From: Brian Banister [REDACTED]
Sent: 19 March 2025 12:58
To: Planning.Responses
Subject: Arun Conservation Area Advisory Panel comments on applications

The **Arun Conservation Area Advisory Panel** wish the following comments to be taken into consideration in the determination of the applications:

AL/22/25/HH - 28 Church Road, Aldingbourne

DWG NO 1407/04
REV B

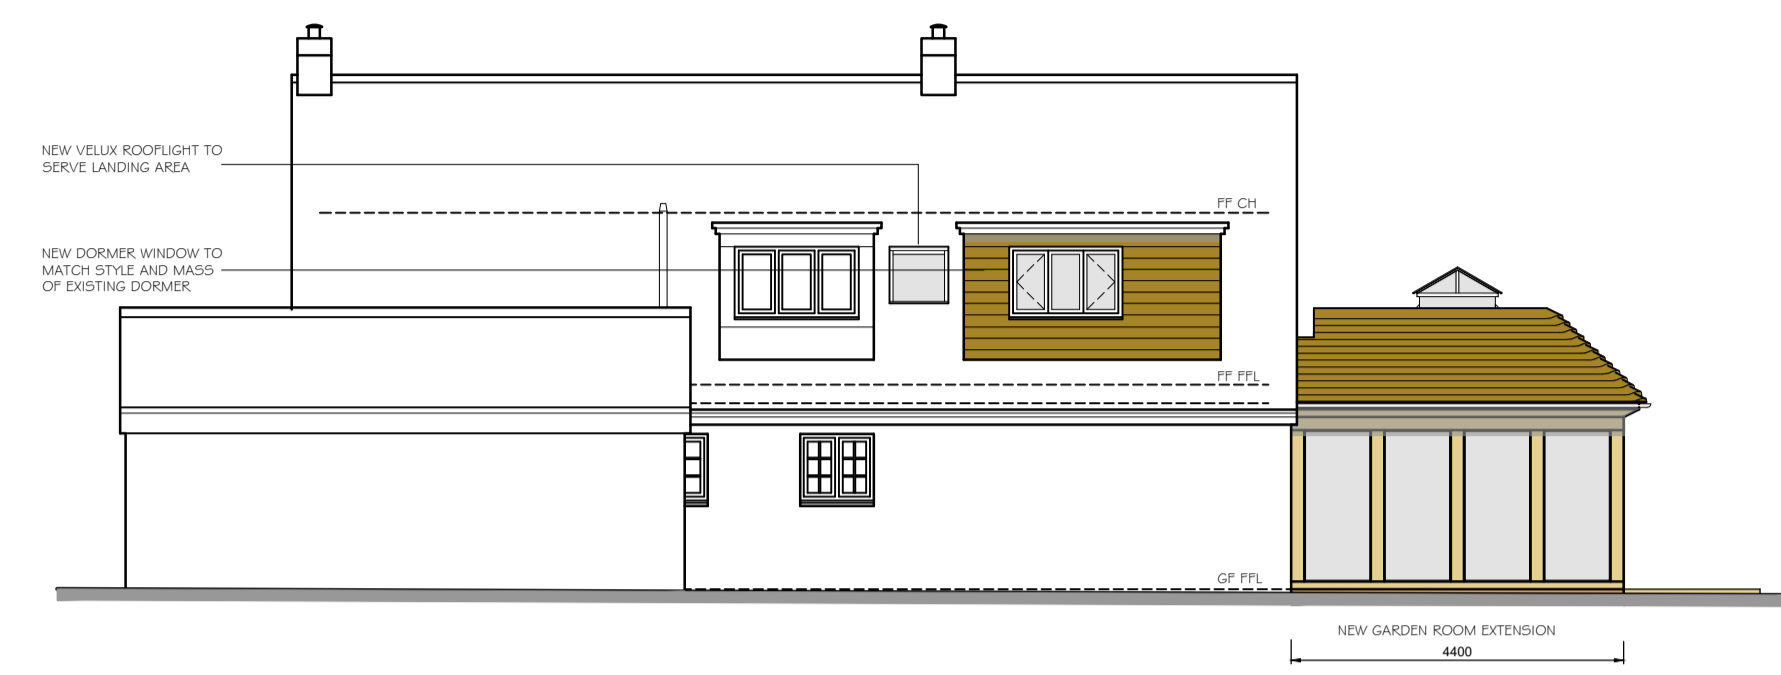
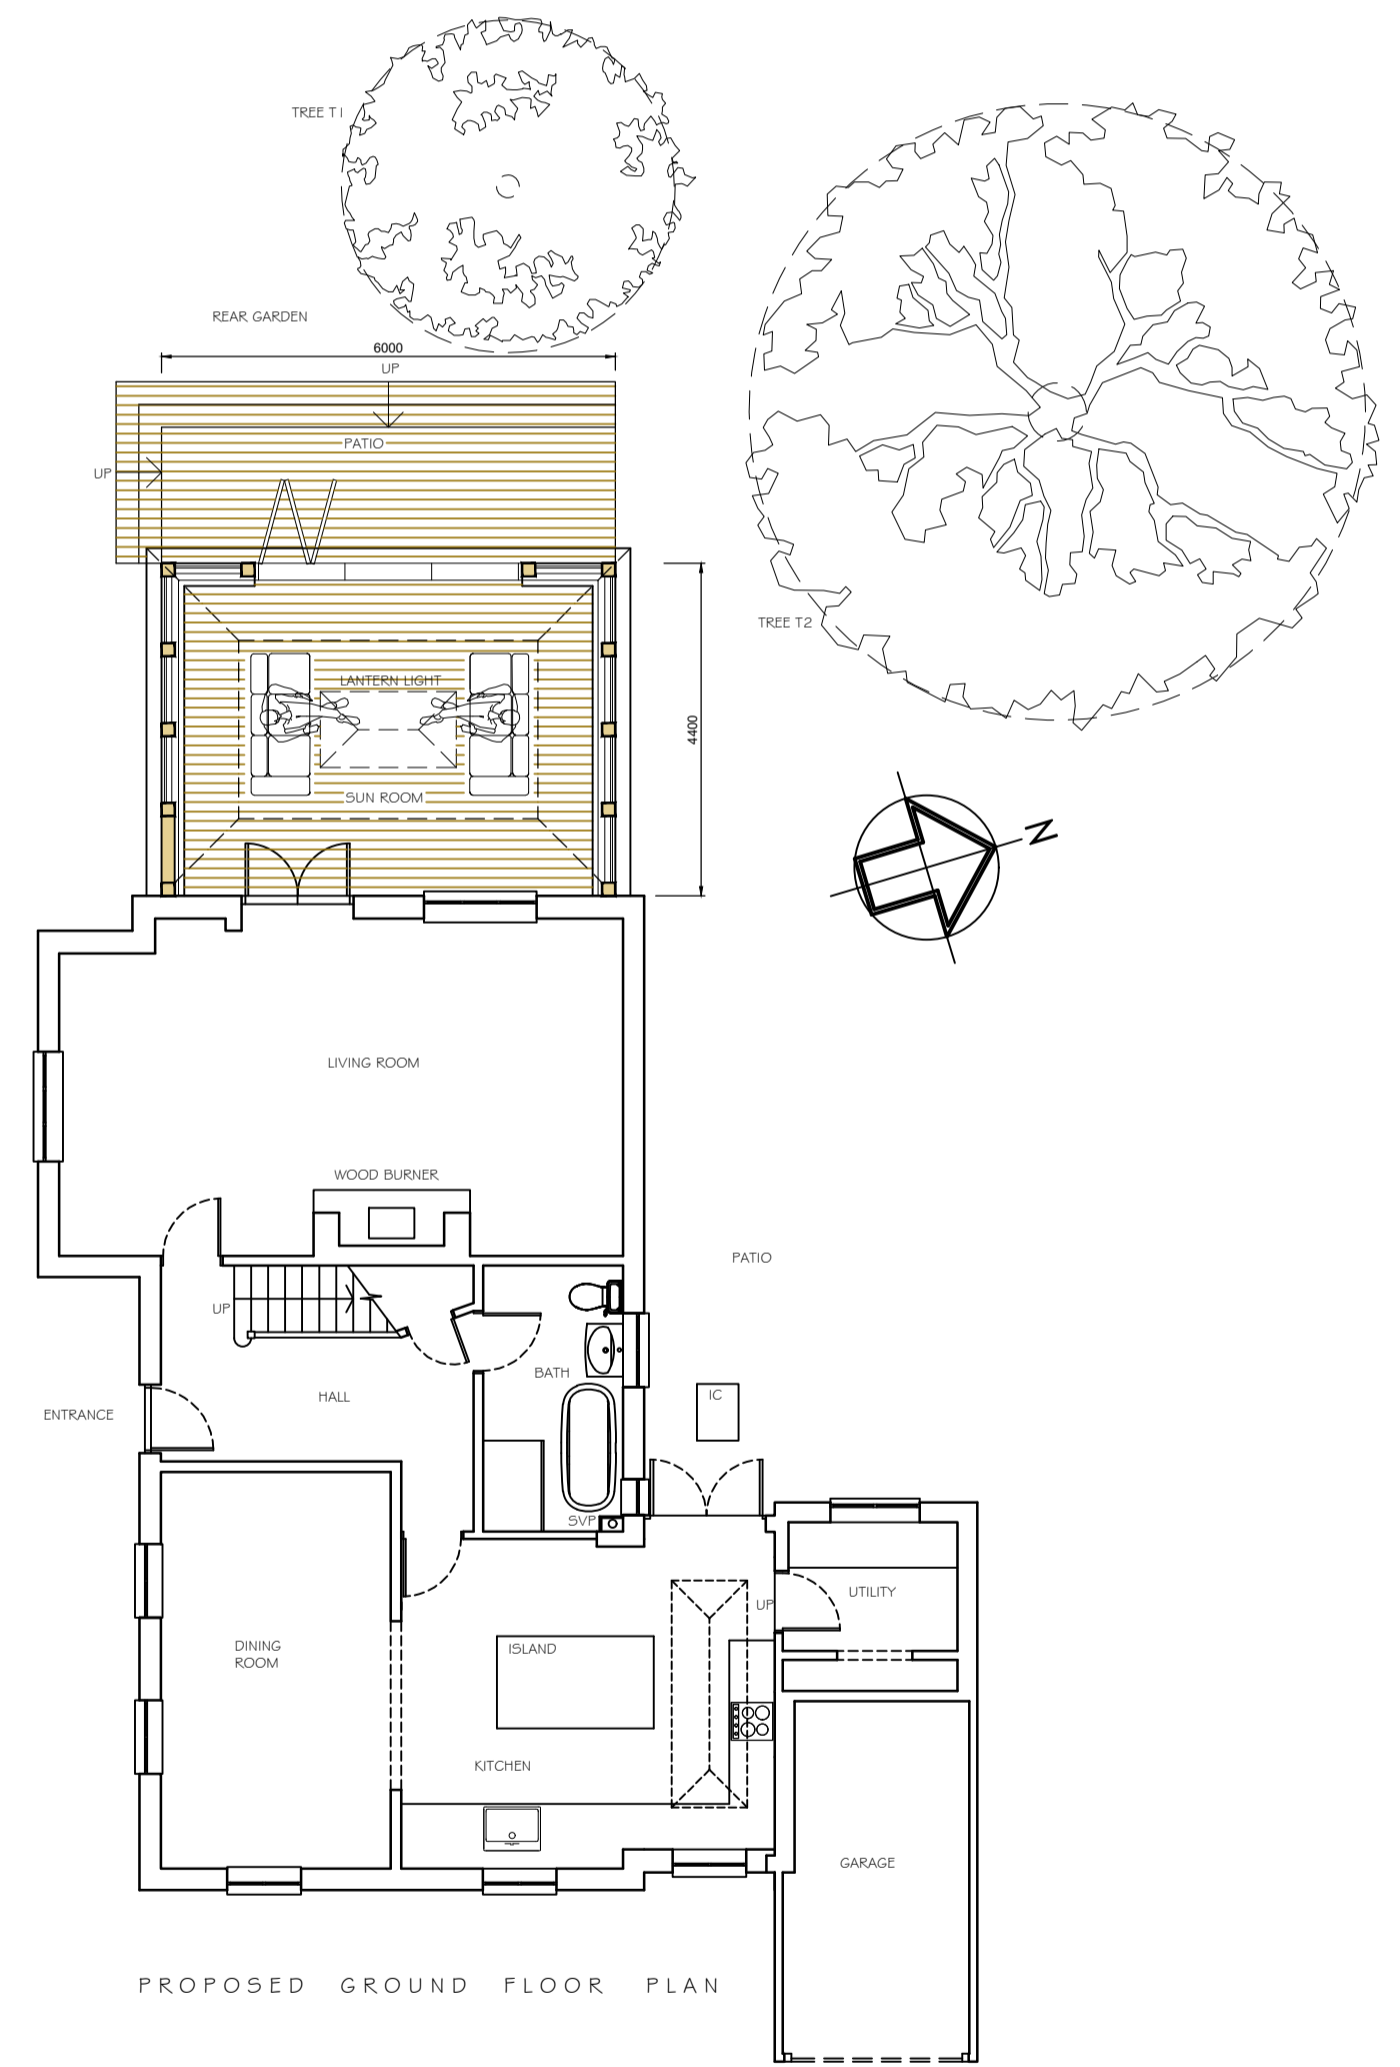
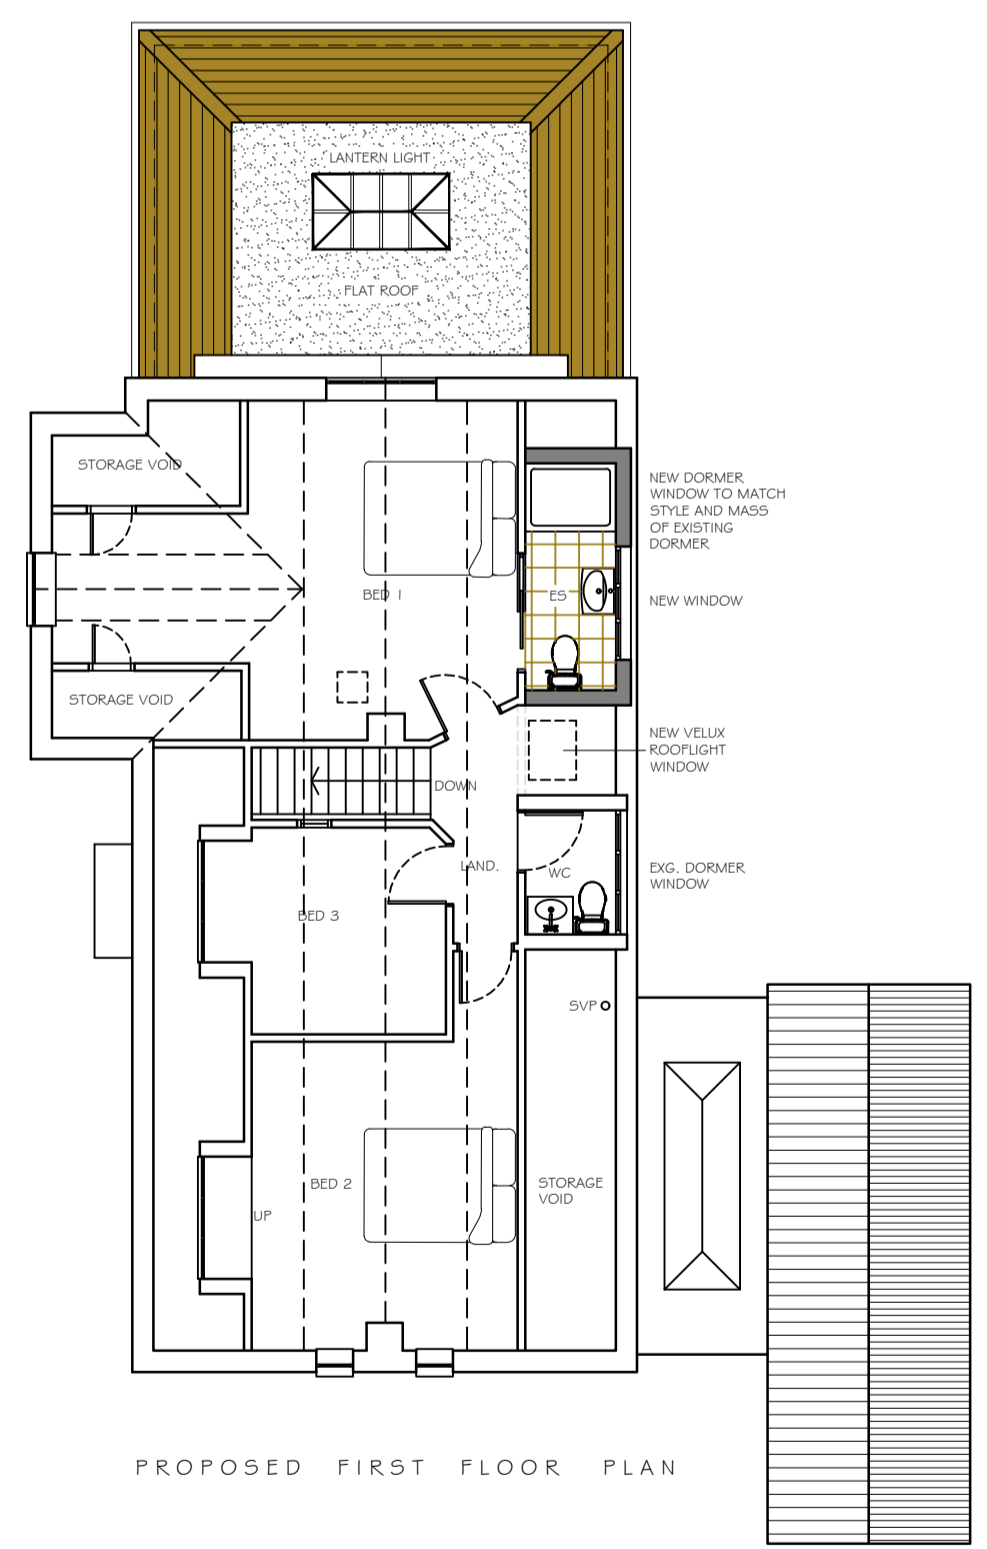
It is recommended that the new clay tiles should match, as far as possible, those on the existing roof.
